**RE: Sonata Unit 4 Trails Apartments  
Tracts 1, 2, and 3, The Trails Unit 4  
Third DRB Submittal**

RESPEC, agent for Sonata Trails, LLC, owner of the above referenced property, is requesting approval from the Development Review Board (DRB) on this Site Development Plan submitted for your consideration. This is the second submittal to the DRB for this project. The first hearing was held on June 3, 2020. Below is a response to comments received at the first DRB meeting.

KEY MAP SCALE: NTS

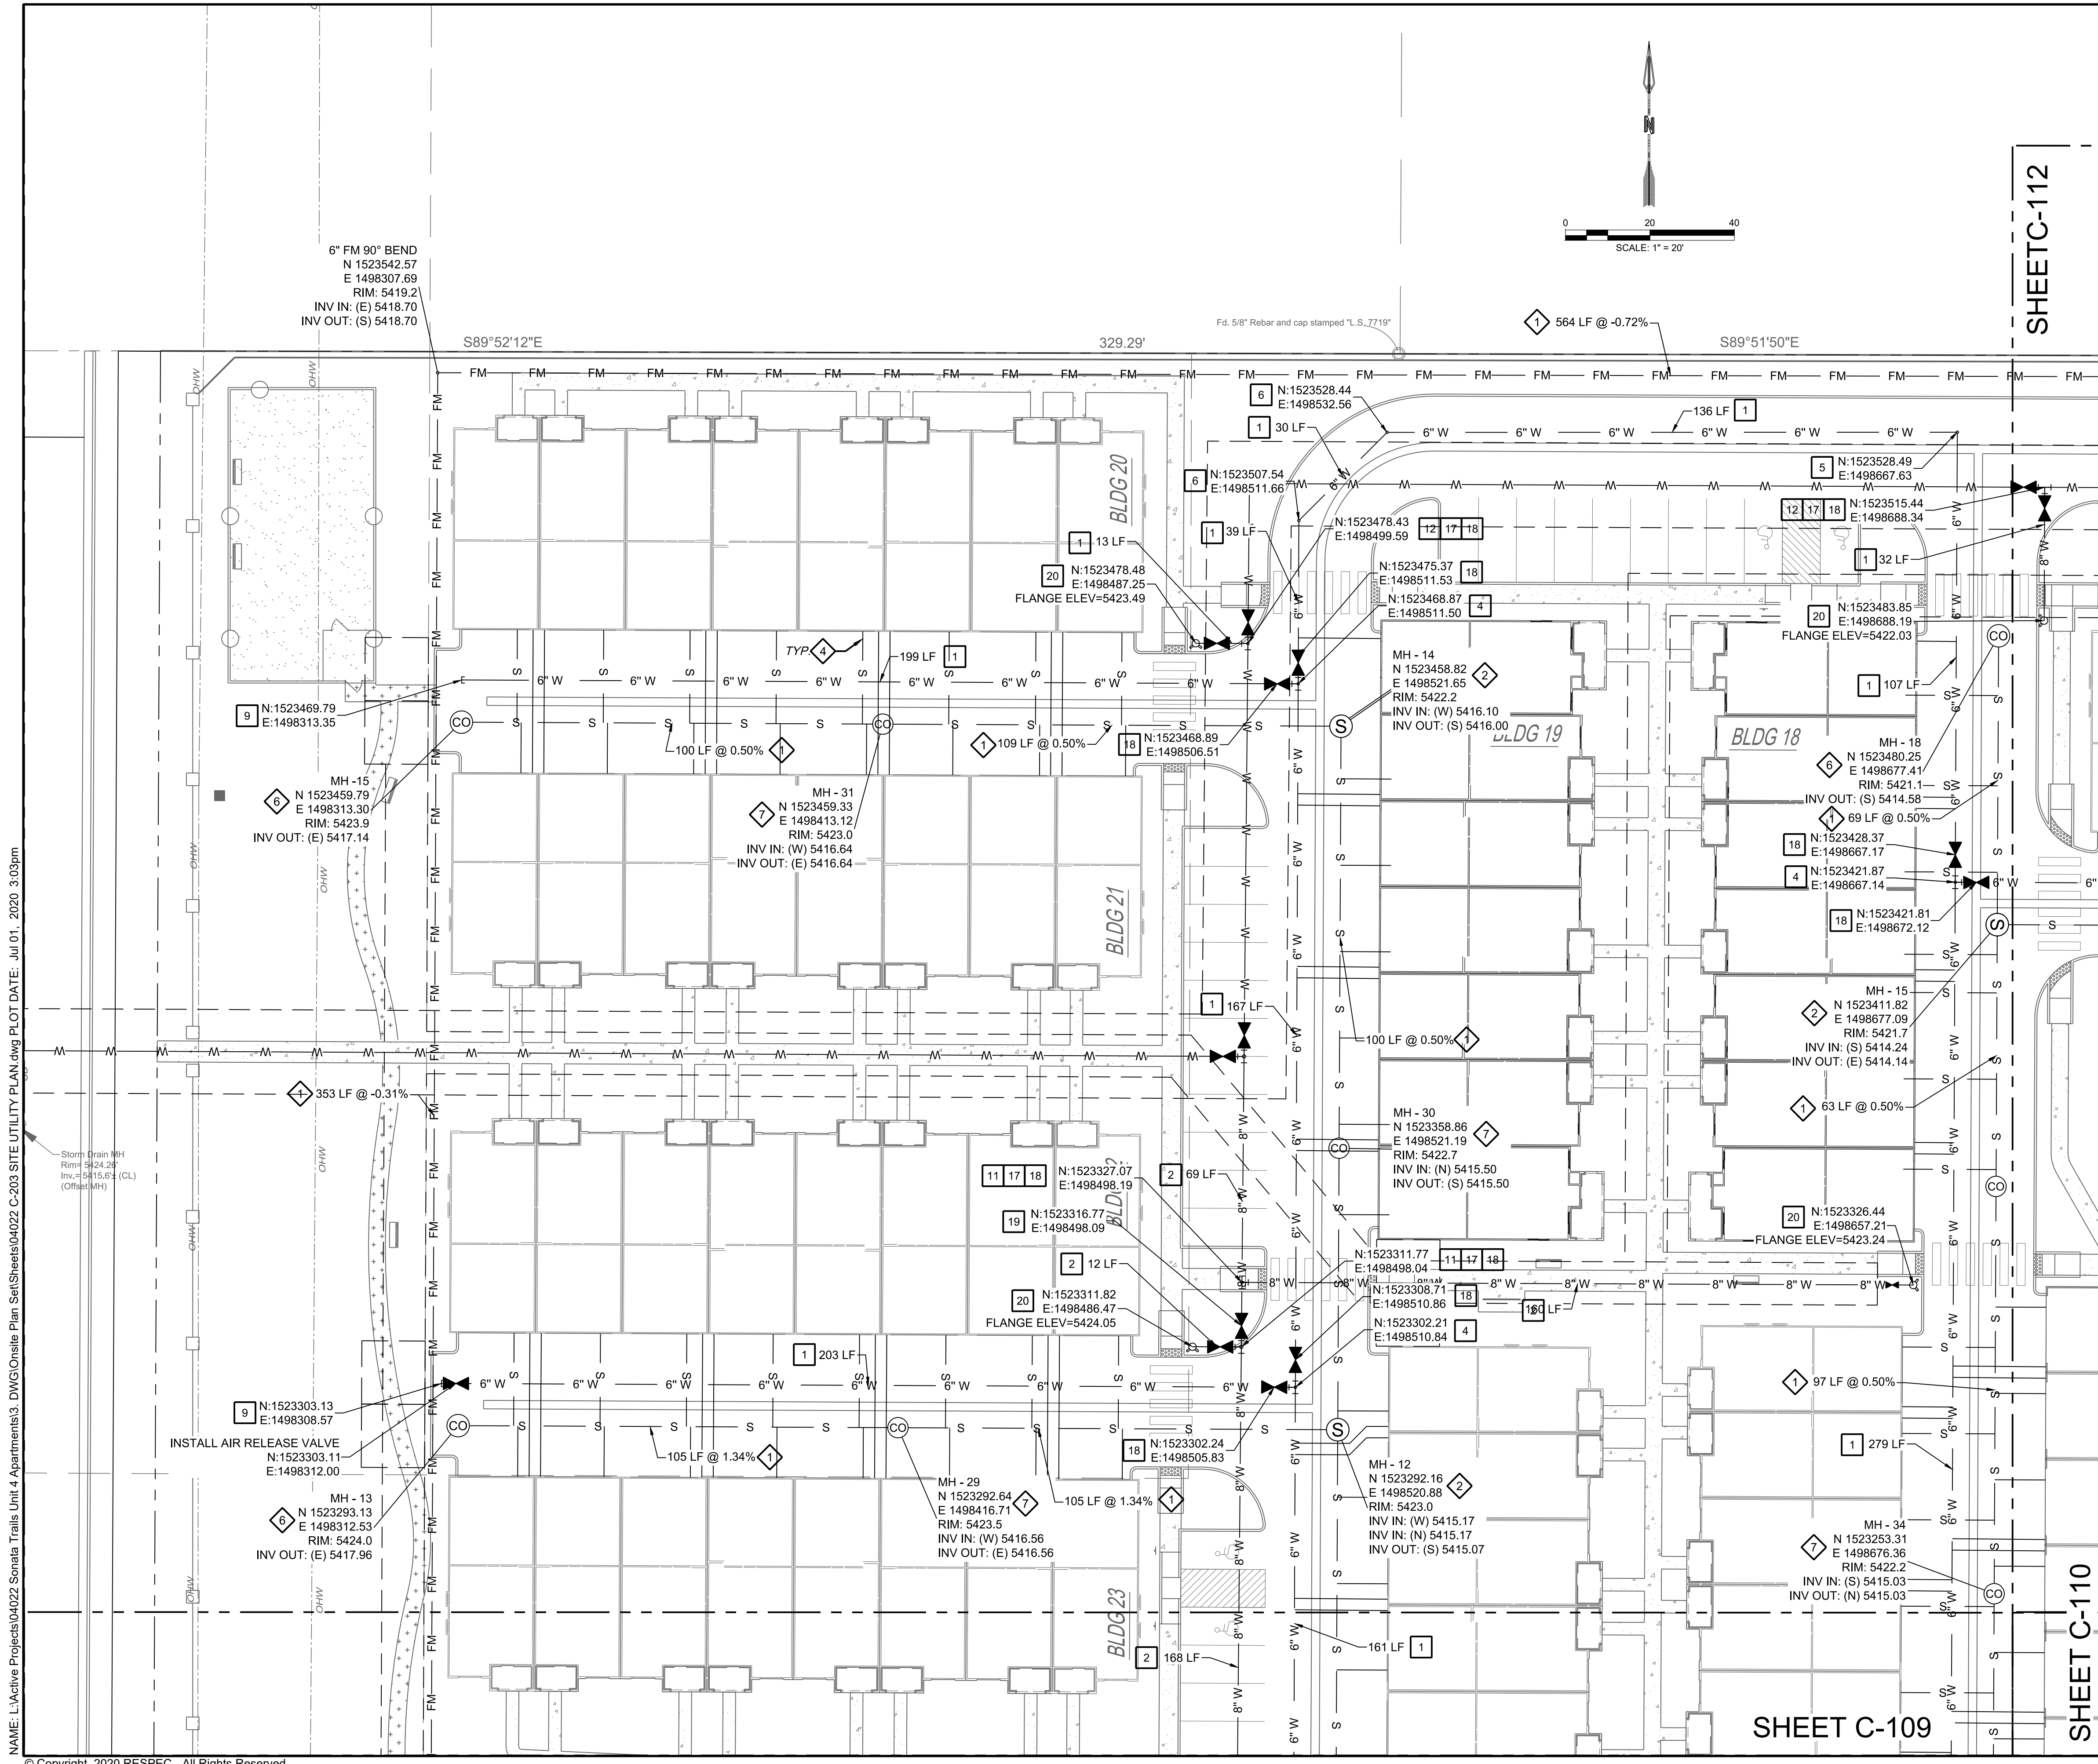
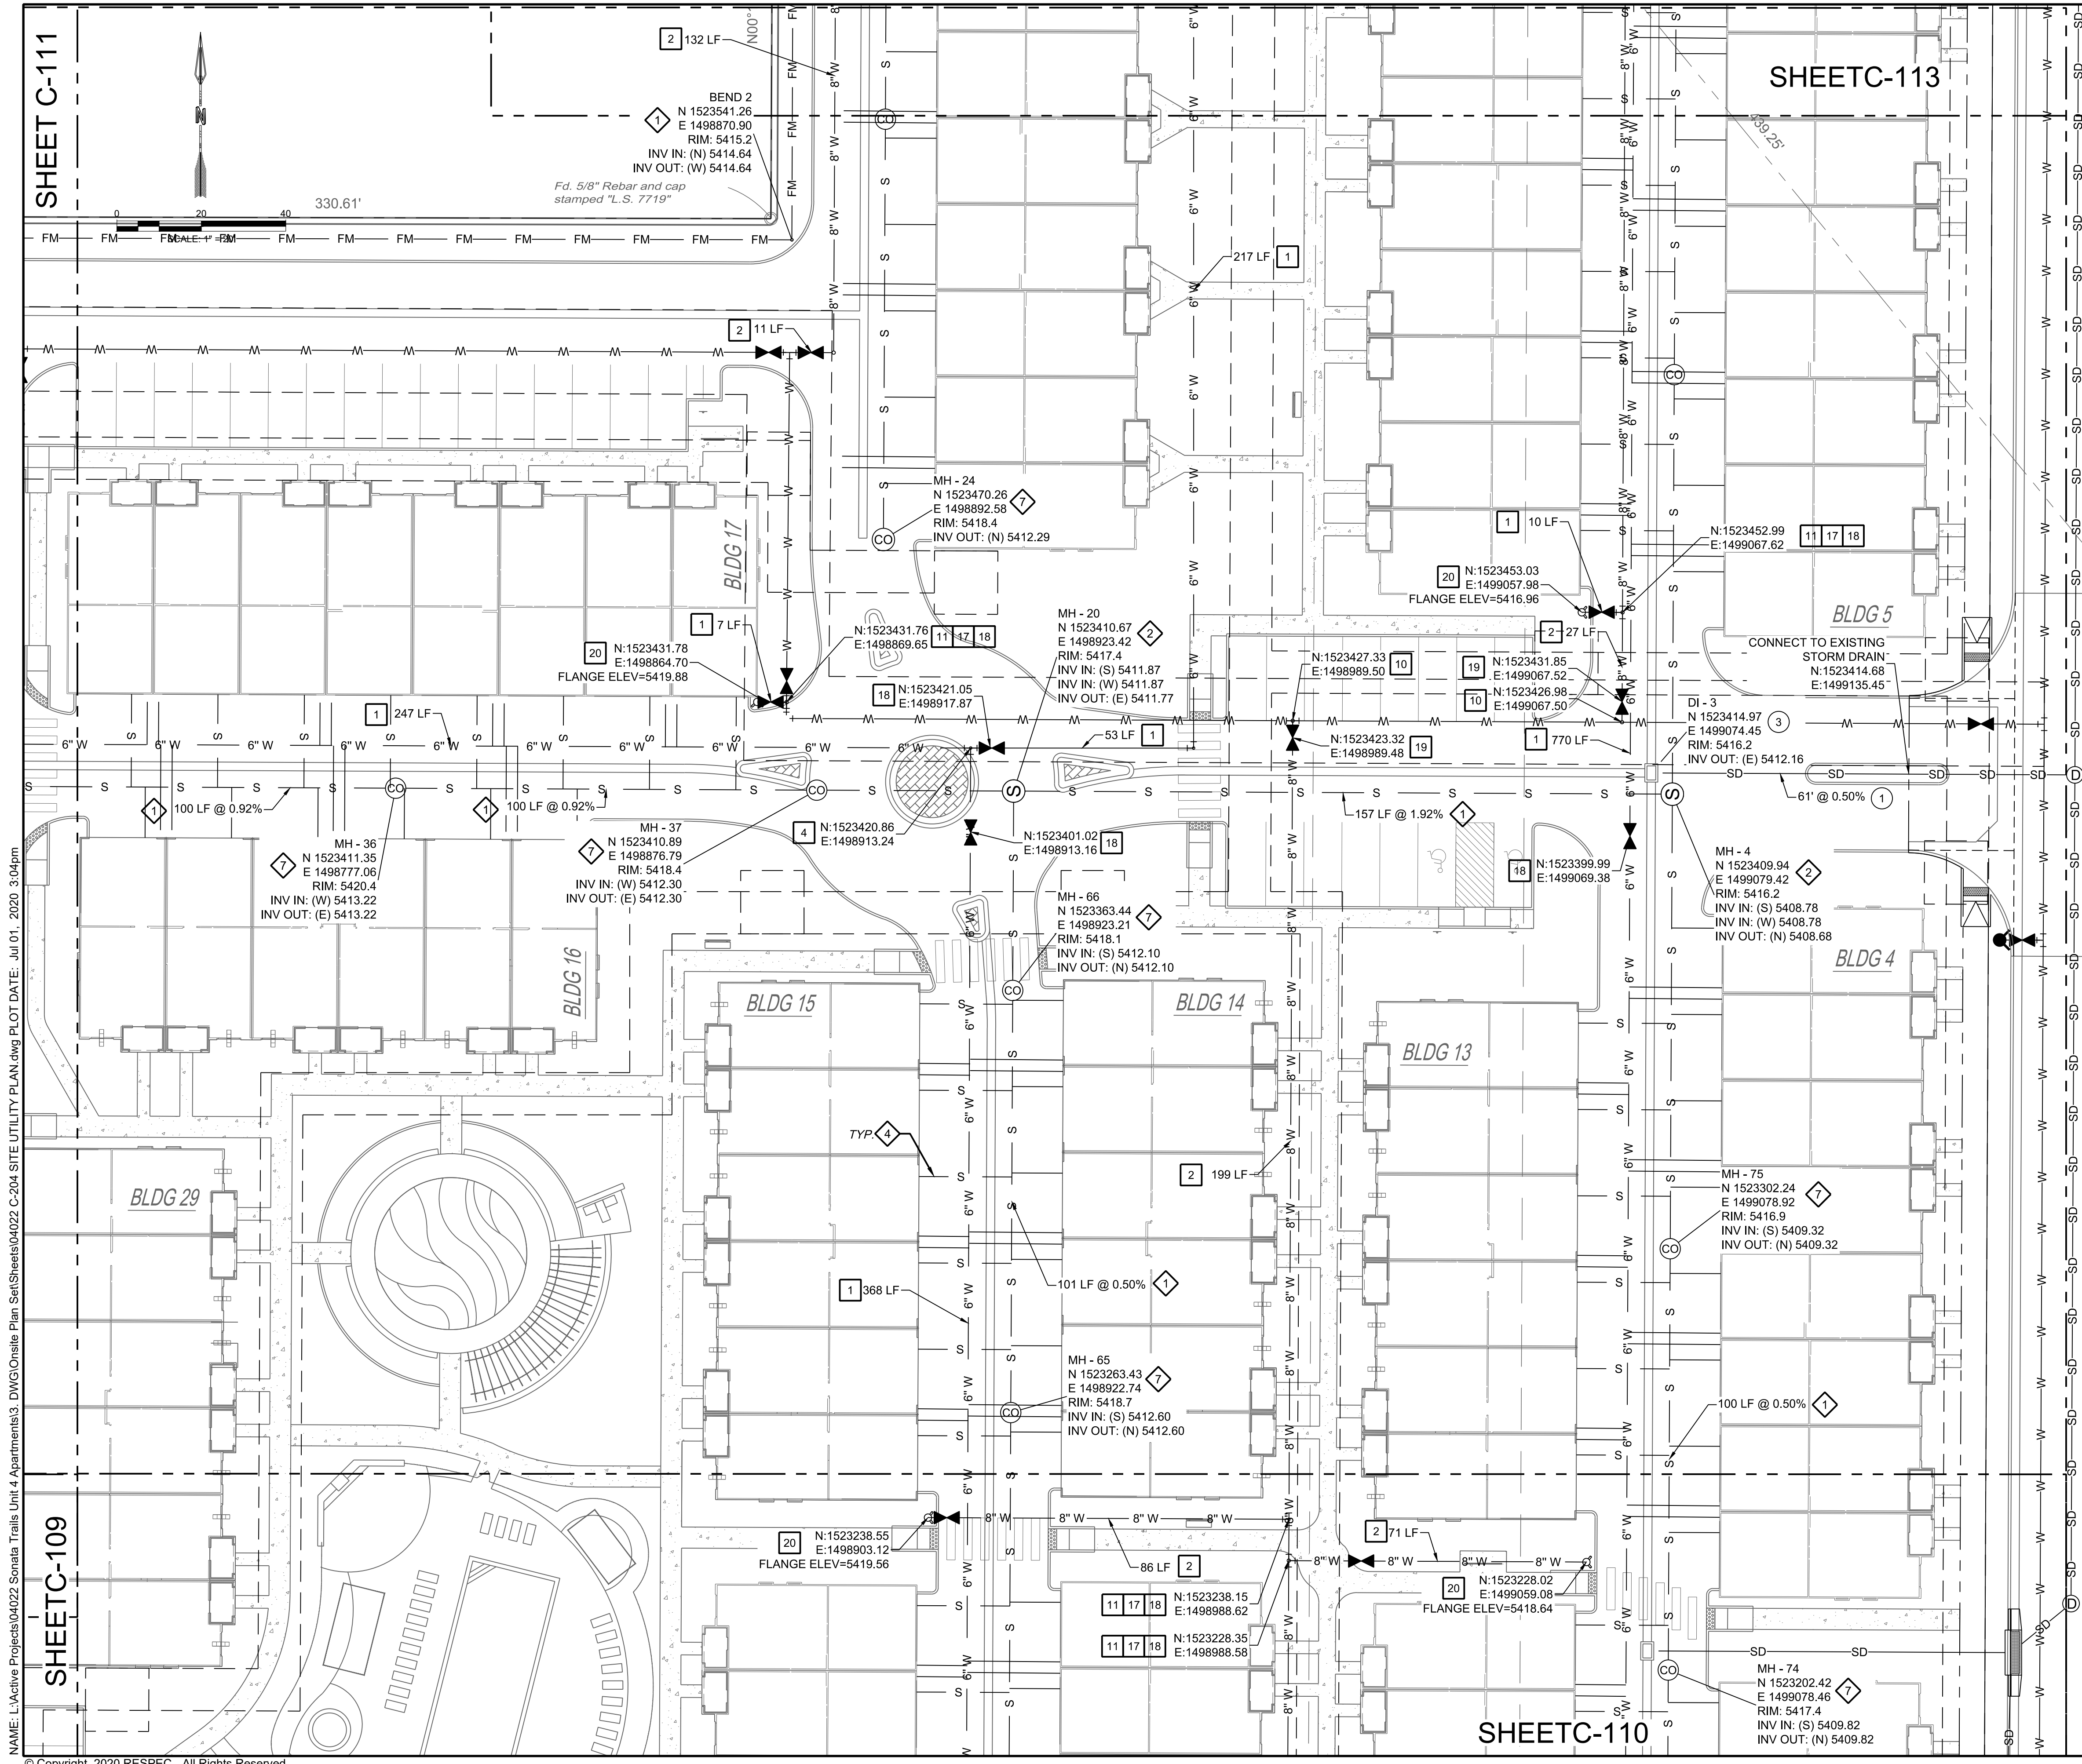
1. The development is outside of the Adopted Service Area. Water Authority Board approval is required prior to Site Plan approval. This will be in the form of a development agreement. The development agreement shall be supplemented by a serviceability letter.
2. A request for availability was received. Serviceability Letter #200426 is currently being researched.
  - a. The official requirements will be stated in the serviceability letter.
3. Utility Plan
  - a. Sanitary sewer
    - i. Construct dry sanitary sewer lines along portion of Treeline Ave. (just enough to provide Tract 3 to the south service) and the entire length of Chatsworth Dr. Label these on the utility plan accordingly.
      1. This shall be reflected on the infrastructure list.
      2. This shall be designed to facilitate future discharge to the future 15" sanitary sewer interceptor.

- ii. The dry sanitary sewer along Oakridge St. can be a deferred item since the roadway will not be constructed at this time. Label this on the utility plan accordingly.
  1. This shall be reflected on the infrastructure list.
  2. This shall be designed to facilitate future discharge to the future 15" sanitary sewer interceptor.

- iii. Construct the public sanitary sewer along Treeline Ave. just enough for a perpendicular service connection.
  - 1. This shall be reflected on the infrastructure list.

- 2. Please confirm if the proposed manhole south of existing manhole C10302 can be eliminated by extending east directly from the existing manhole along Treeline Ave.

- iv. A proposed lift station is shown at the northeast corner of the subject development which ultimately discharges to proposed public gravity sanitary sewer along Treeline Ave. at the southwest corner of the development.

- 1. Considering the potential interim condition with the private lift station, the Utility Plan should show the phases.
    - a. The interim use of a private lift station and the trigger to eliminate the private lift station and discharge to public sanitary sewer that flows to the proposed interceptor along Paseo Del Norte/Avenida De Jaimito when it is available may need to be detailed in the development agreement.

- v. Label proposed lift station and onsite sanitary sewer as private (both force main and gravity sewer).
- / Proposed lift station and onsite sanitary sewer has been labeled as private. See revised utility sheets.

- b. Water
    - i. Differentiate public waterline and private waterline onsite.
- / Labels have been added to differentiate between private and public waterlines. See revised utility sheets.

- ii. Public waterline needs to be shown along Treeline Ave., Chatsworth Dr. and Oakridge St. frontages. Also, an onsite public waterline shall be provided to provide a looped waterline connection. This shall be in an alignment that provides access for maintenance and operation.

- iii. The public waterline along Oakridge St. can be a deferred item since the roadway will not be constructed at this time. Label this on the utility plan accordingly.

/ Dry sanitary sewer added along a portion of Tree Line Ave to serve Tract 3. This is shown on the plan and on the infrastructure list. General Note 13 states that "all utility improvements located within the right-of-way are public." General Note 14 states that "all utilities shown located within the private property shall be private unless otherwise noted." Labels have also been added as well to differentiate between private and public infrastructure. See revised utility sheets and infrastructure list.

/ As you are aware, we are working with transportation and their request to construct our entire roadway frontage surrounding the development. No change has been made

- / Public sanitary sewer along Tree Line Ave for a service connection has been provided and shown on the plan and infrastructure list. The proposed manhole has been eliminated and a tee/wye connection is being proposed. See revised utility sheets and infrastructure list.

- / Public waterline is provided and shown in Tree Line, Chatsworth, and onsite. Water will be shown at the northeast corner and Oak Ridge once further direction is received from Transportation. See revised utility sheets.

- / No change has been made at this time pending determination on how to proceed with this area from Transportation.
